**ESR Horsley Logistics Park-Mod-1 (SSD-10436-Mod-1)
Request for additional information**

I refer to the response for additional information submitted for the ESR Horsley Logistics Park-Mod-1 (SSD-10436-Mod-1). The Department concurs with Fairfield City Council comments on the modification dated 27 May 2021 and 25 June 2021 and has concerns with the potential for conflict between vehicles. The Department provides the following comments:

DEVELOPMENT APPLICATION
 DRAWING TITLE: LOT 201 SITE & FACILITY PLAN
 DRAWING NUMBER: 200226 - DA - 201-A100
 P17

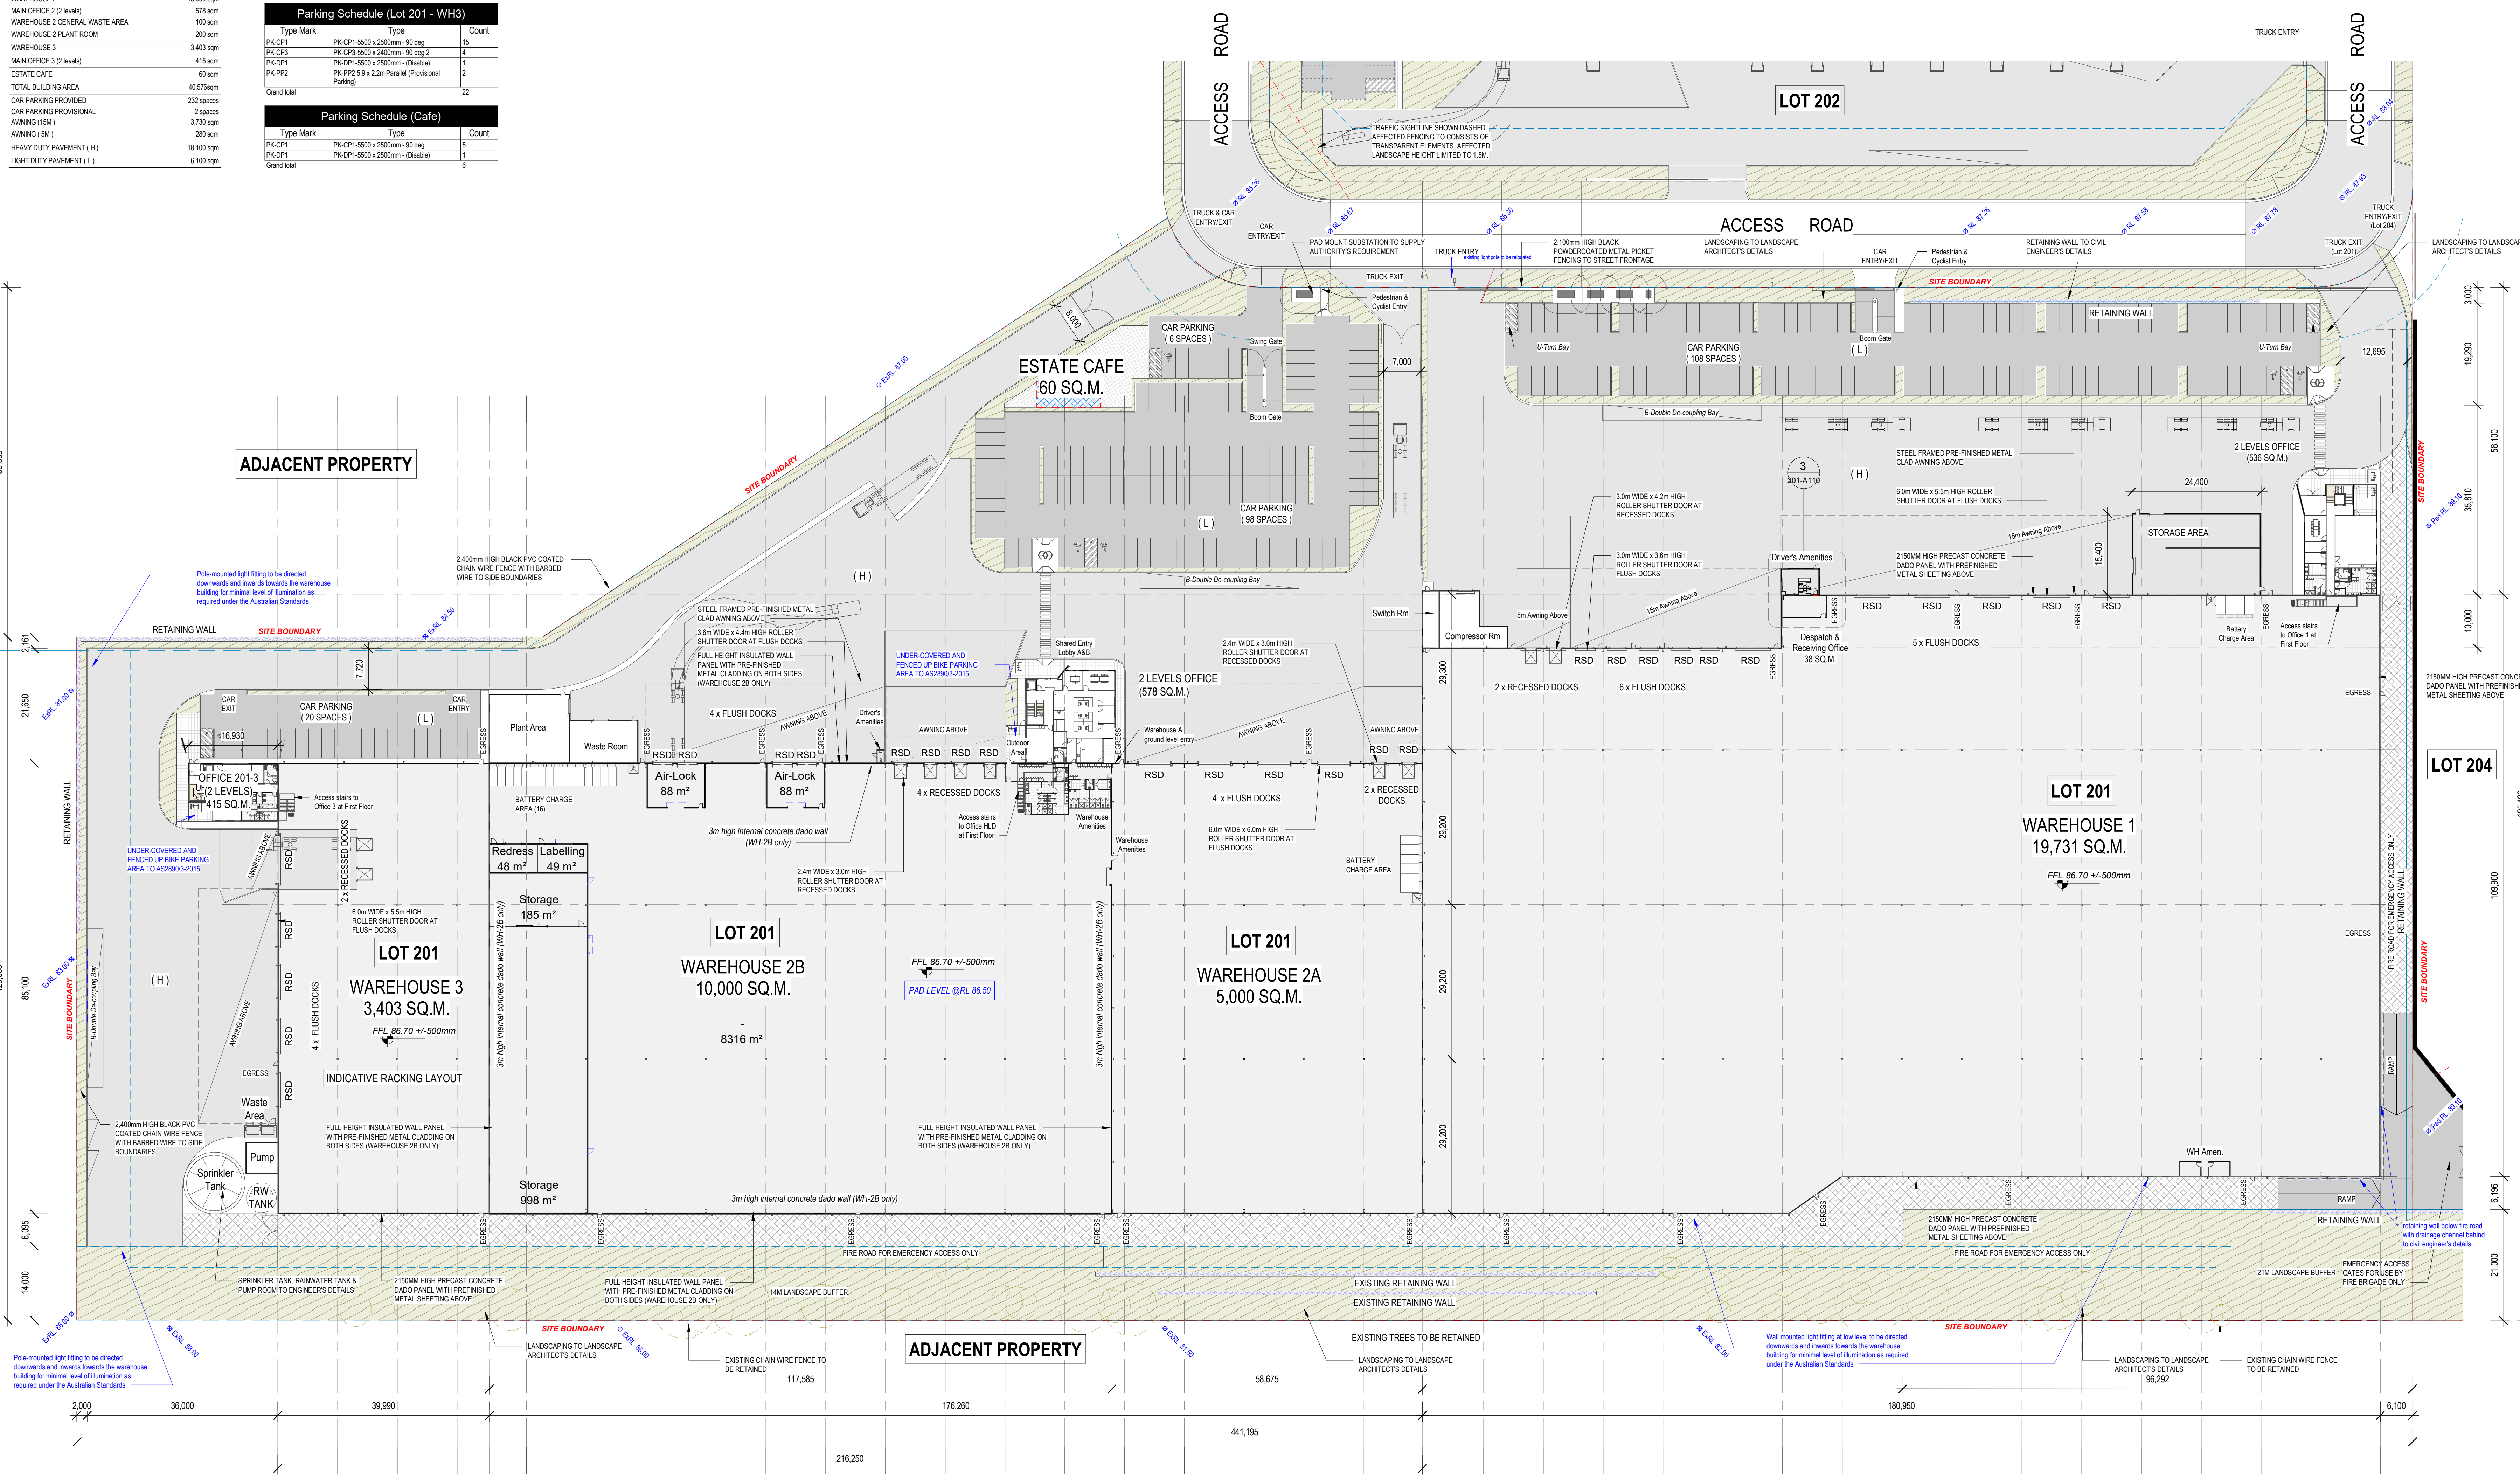
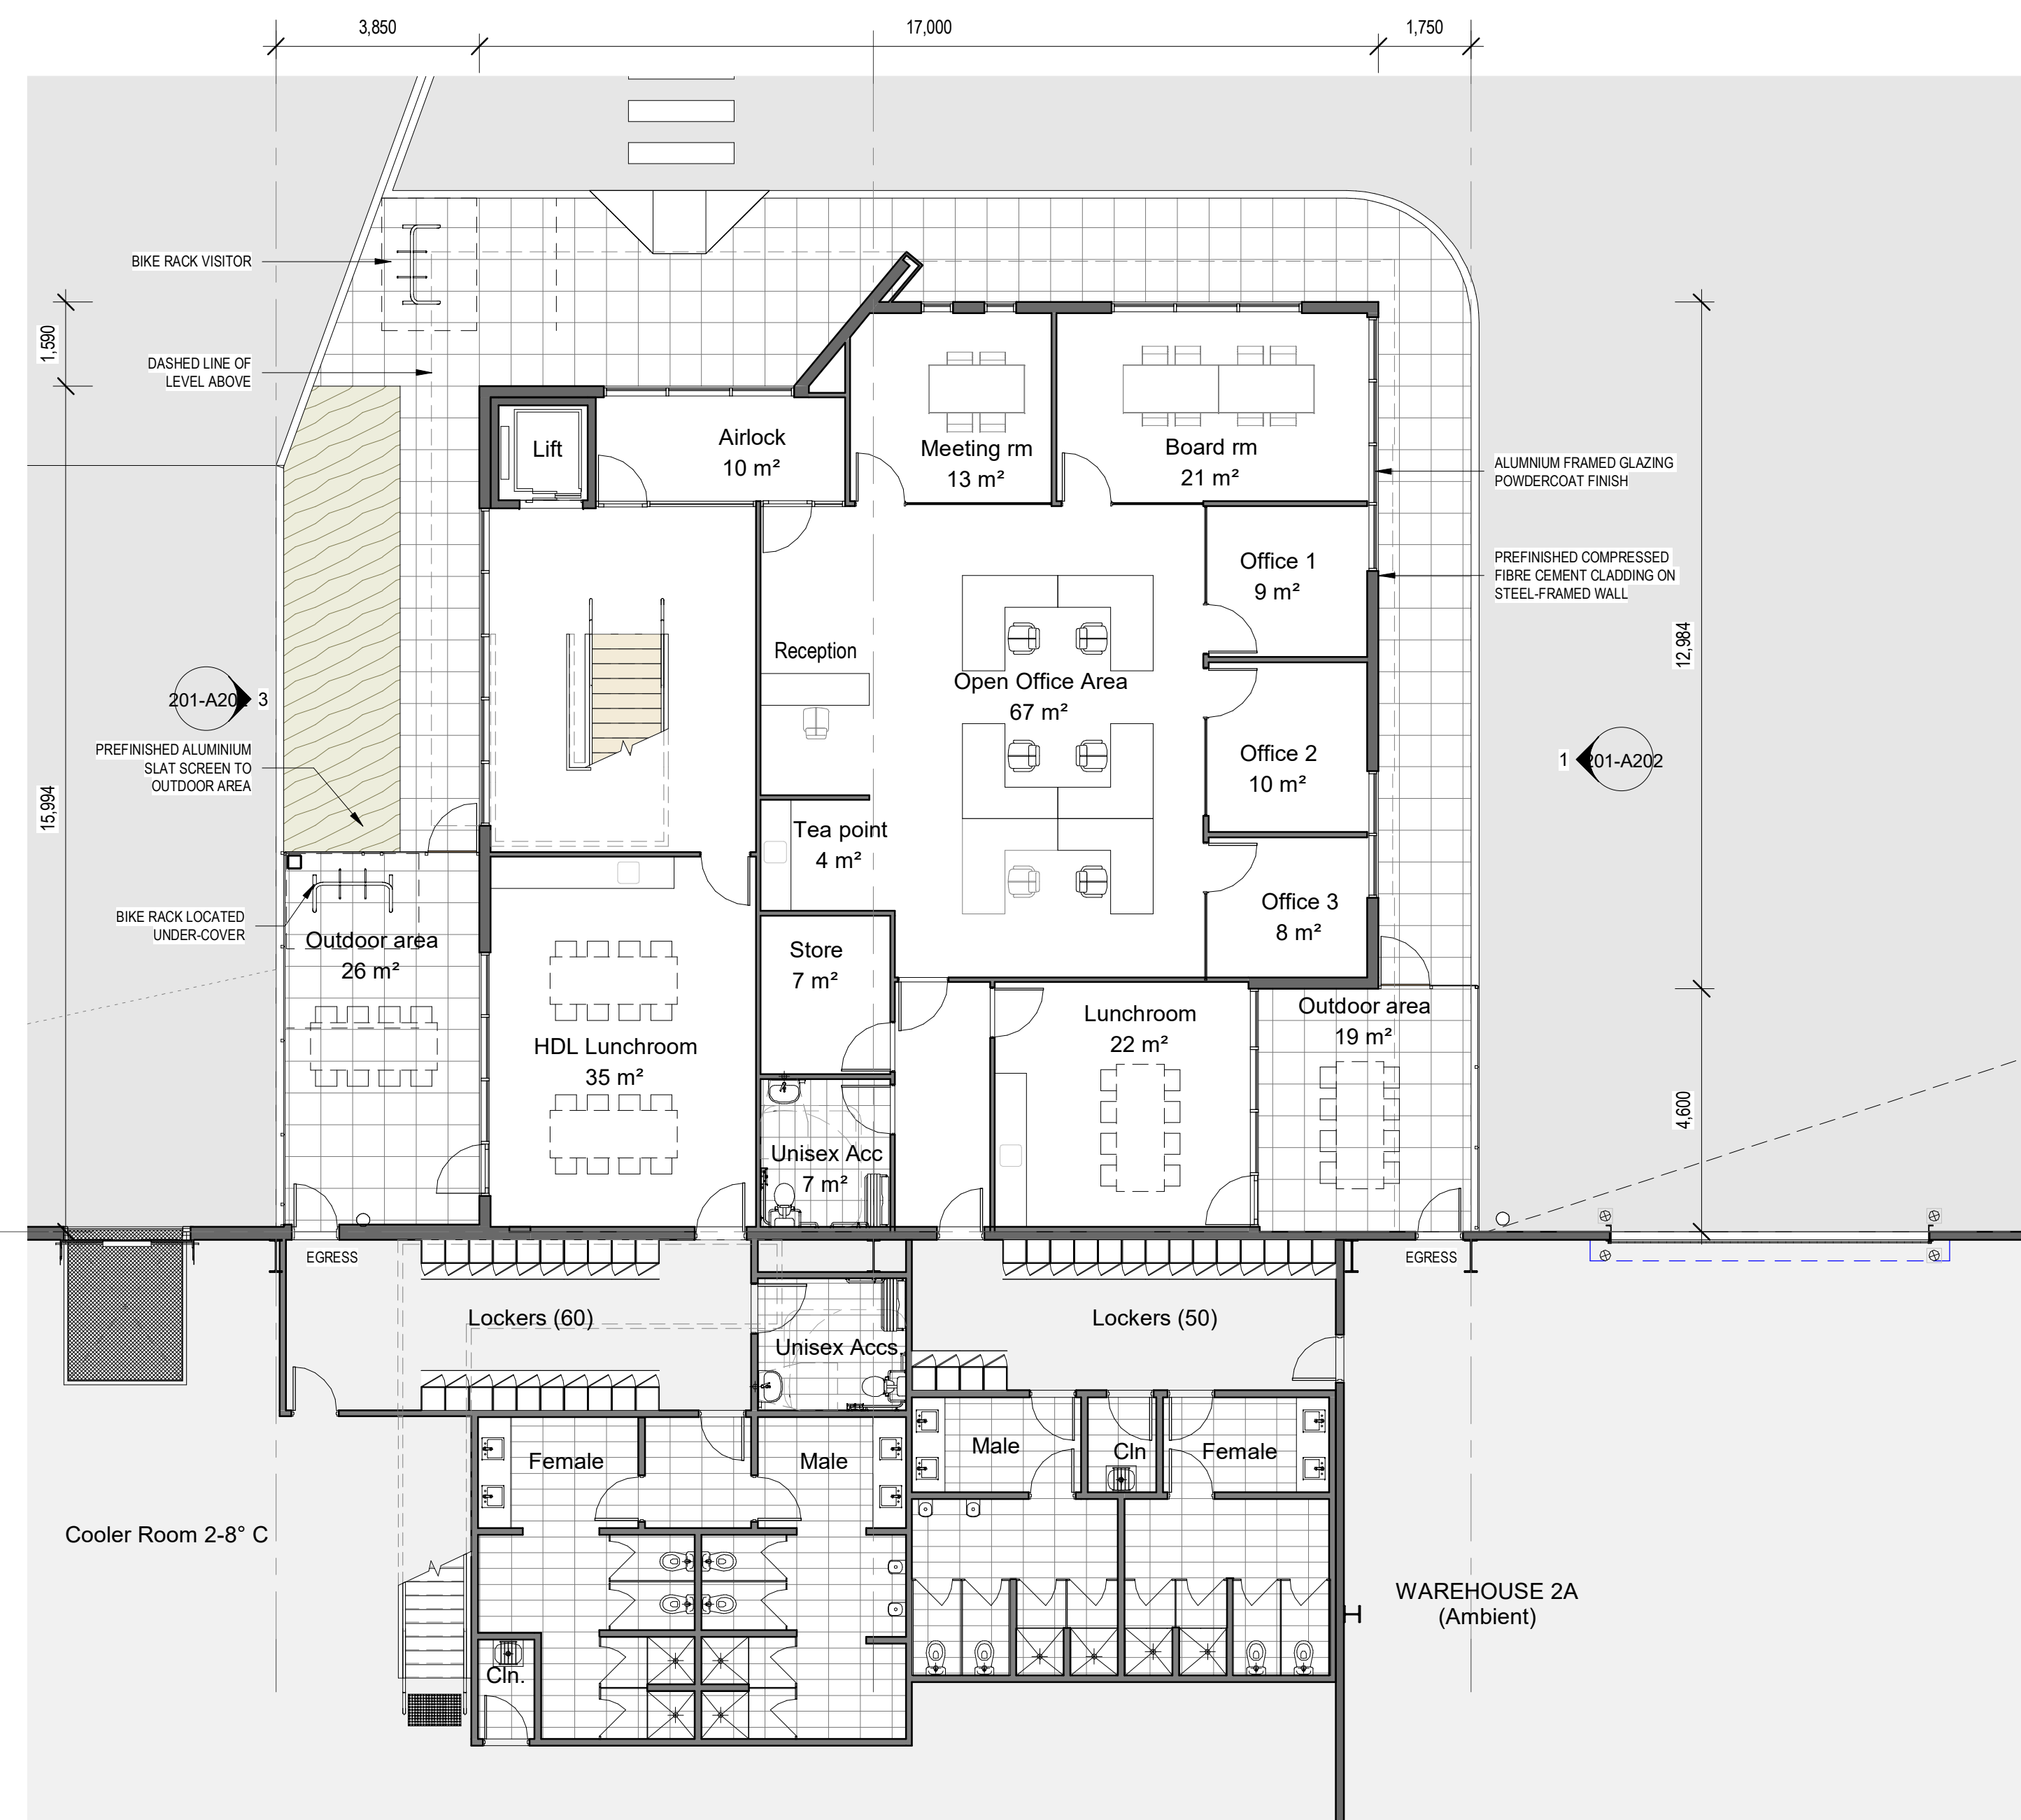
- There is the potential for conflict between all vehicle types entering and exiting the multiple driveways at the Johnston Crescent bend. For example, from the swept path analysis provided, it is unclear how heavy vehicles can enter and exit the site simultaneously at the driveway labelled "Truck & Car Entry/Exit". Further, delays in entering the site have potential to impact the flow of traffic on Johnston Crescent.
- There is potential for conflict between all vehicle types within Lot 201, particularly at Warehouses 2 and 3. For example, from the swept path analysis provided, it is unclear how heavy vehicles can travel to and from Warehouse 3 simultaneously at the north-west corner of the site. Additionally, there is potential for conflict between heavy vehicles and light vehicles accessing car park on the northern side of Warehouse 3.
